Great North Road Solar and Biodiversity Park

Draft Statement of Common Ground with Nottinghamshire County Council

Document reference – EN010162/APP/8.1A

January 2026

**Archaeology and Cultural Heritage
Study Area
Figure 11.1**

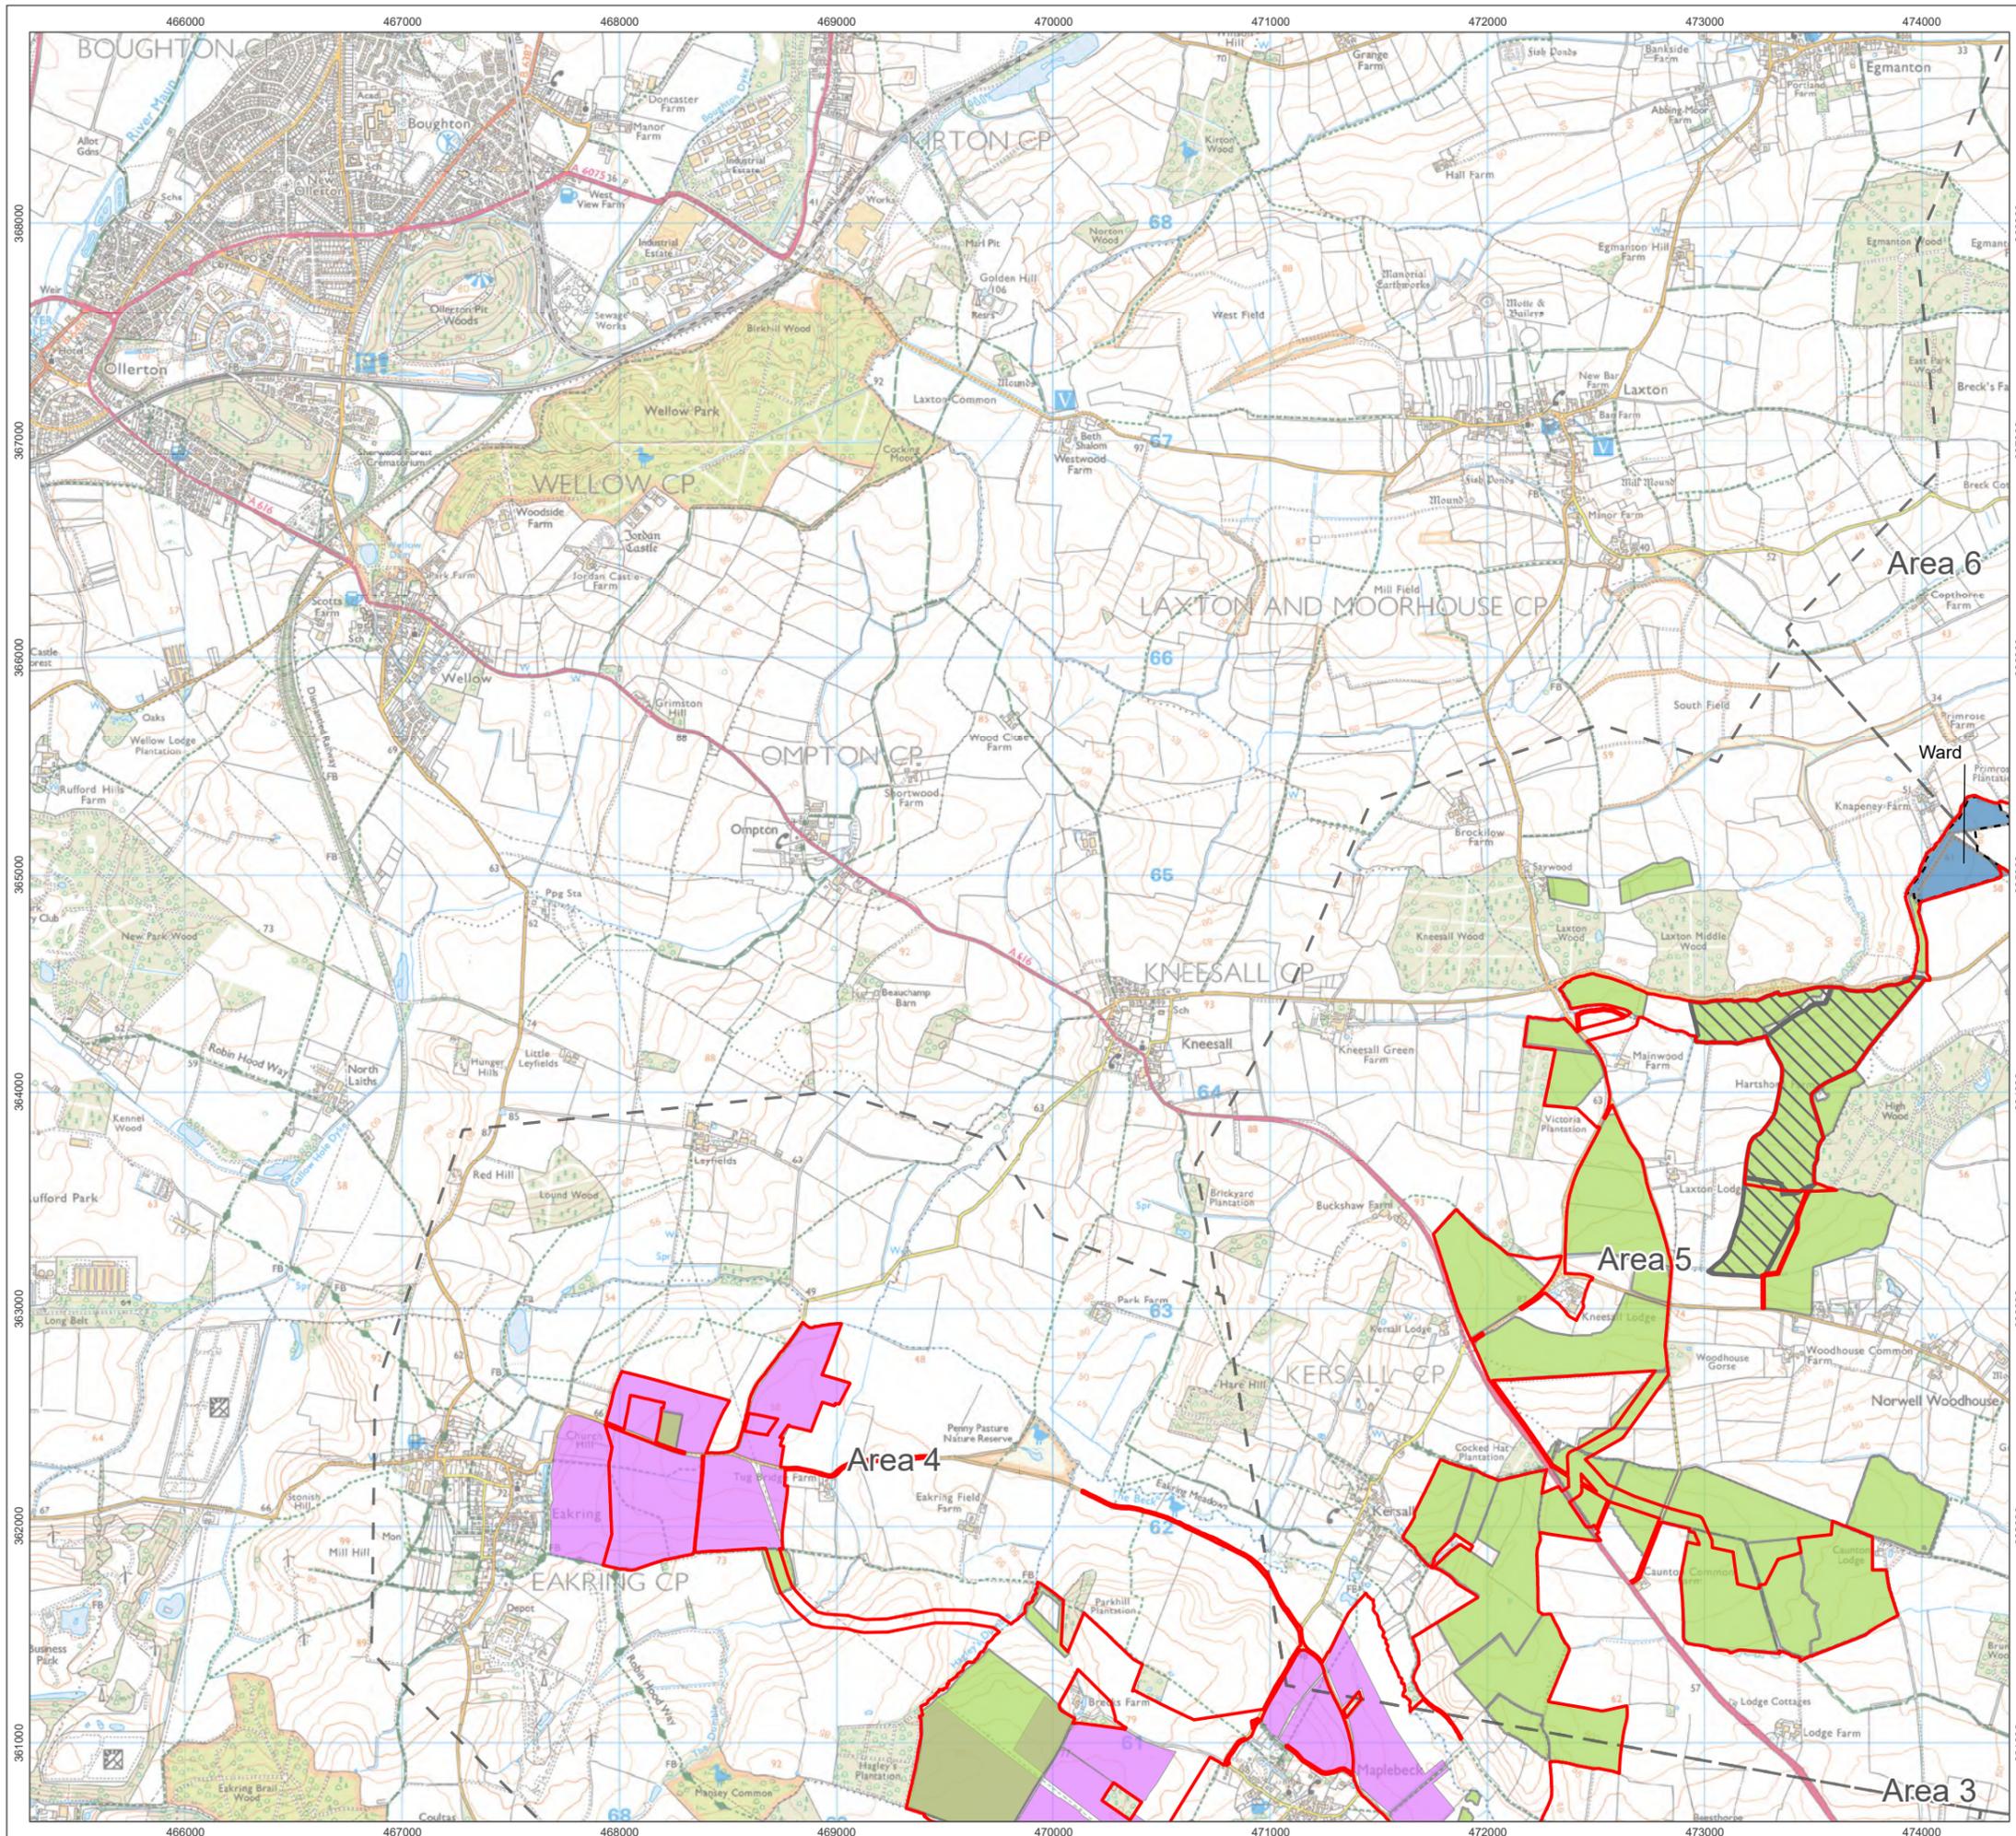
2.2.4	Section 42 Statutory Consultation in the Consultation Report	Scope of Cultural Heritage Assessment (Study Area for the Assessment)	The Parties agree that study area for the assessment is acceptable, and is presented in Section 11.4.2 the ES Volume 2, Chapter 11: Cultural Heritage and Archaeology [EN010162/APP/6.2.11] [APP-	Noted.	Agreed

Ref	Relevant Documents	Description of Matter	Applicant's Position	NCC's Position	Status
			054]. The study area map is provided in ES Volume 3, Figure 11.1: Archaeology and Cultural Heritage Study Area [EN0101/APP/6.3.11A] .
